Appeal Decision

Appeal Ref: APP/R5510/D/21/3280596

9 Kewferry Drive, Northwood, HA6 2NT

- The appeal is made under section 78 of the Town and Country Planning Act 1990 against a refusal to grant planning permission.
 - The appeal is made by Mr Pankaj Patel against the decision of London Borough of Hillingdon.
 - The application Ref 32794/APP/2021/1450, dated 10 April 2021, was refused by notice dated 8 June 2021.
 - The development proposed is a two-storey rear extension, conversion of garage to habitable use, front porch, alterations to the roof, first floor wraparound balcony and alterations to fenestration.
-

Proposed 1st Floor Plan

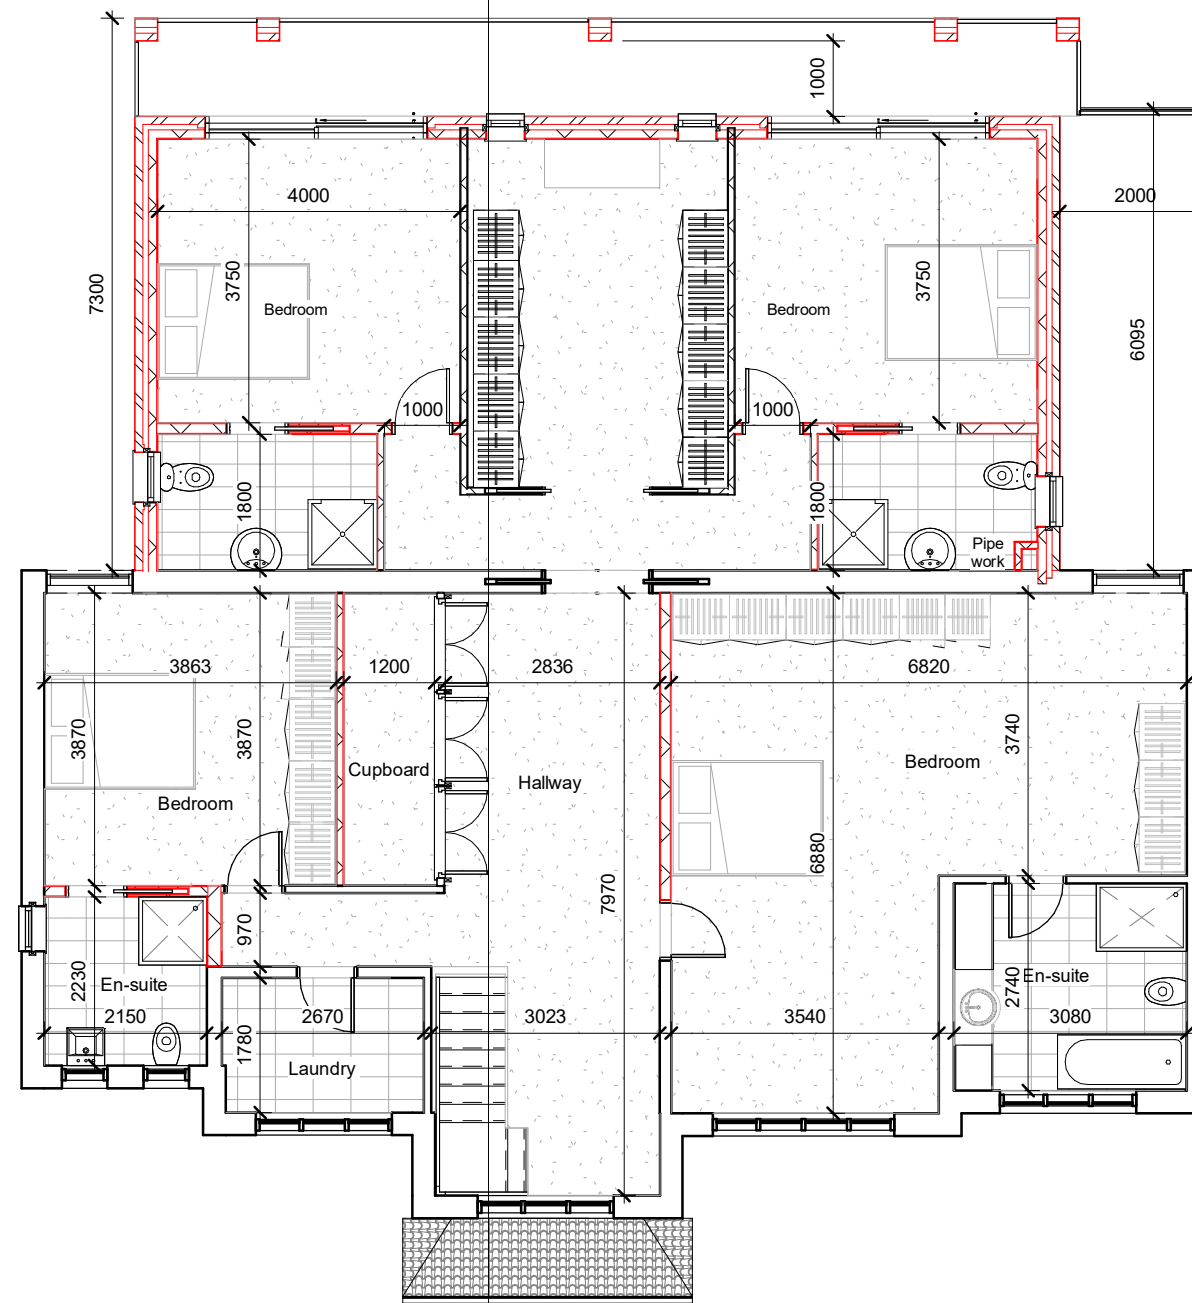
8. The submitted plans show a balcony area to the first floor of the rear elevation of the appeal property. The balcony is shown as being a relatively small area, being a little over 1m deep. The appellant states that the flat roof to the western boundary of the site is not to be provided as a balcony and no access from the first-floor bedrooms will be provided.

9. I note that the submitted plan 'South Elevation' shows railings extending the depth of the flat roofed extension, though without an obvious point of access. Nonetheless, the submitted plans show that the western and eastern sides of the proposed balcony would be open, allowing views directly towards the neighbouring properties.

11. Nonetheless the balcony would provide views directly towards the neighbouring properties in an elevated position and despite the landscaping to the boundary, would result in a loss of privacy and introduce a sense of being overlooked for the occupiers of Nos 7 and 11.

Proposed Roof

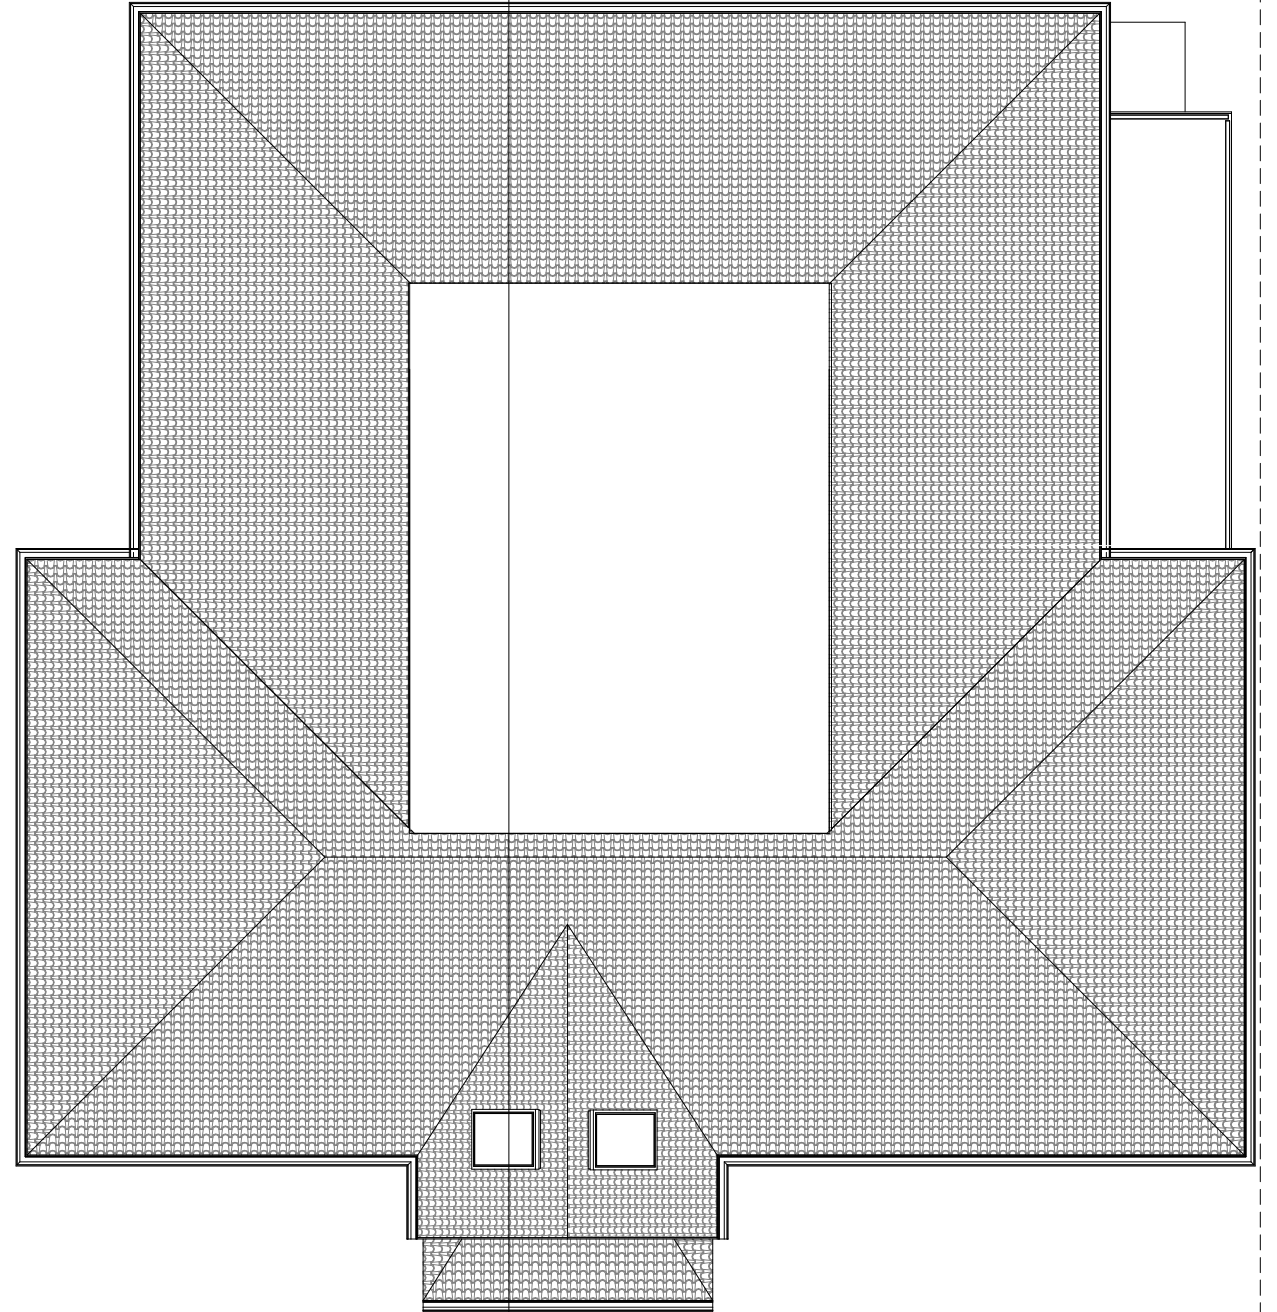
4. The submitted plans show that the proposed development is of considerable scale of itself and in respect of the already large existing appeal property. As a result of the significant extension enveloping the rear of the property, including the balcony, the crown roof is necessarily large and bulky and as a result would fail to respect the architectural character of the existing dwelling. In combination, these extensions would subsume the original dwelling fundamentally altering the character and appearance of the property.

7. Nonetheless, as a result of the significant scale of the proposed extensions and the resulting bulky roof design I find that the appeal scheme would harm the character and appearance of the area, including the appeal property contrary to Policy BE1 of the Hillingdon Local Plan: Part 1 which requires new development to achieve a high quality of design in all new buildings, Policy DMHB 11 and Policy DMHB 12 of the Hillingdon Local Plan: Part 2 – Development Management Policies that, amongst other matters, requires proposals to harmonise with local context taking into account adjacent structures, established street patterns, building lines and architectural composition and be well integrated with the surrounding area.
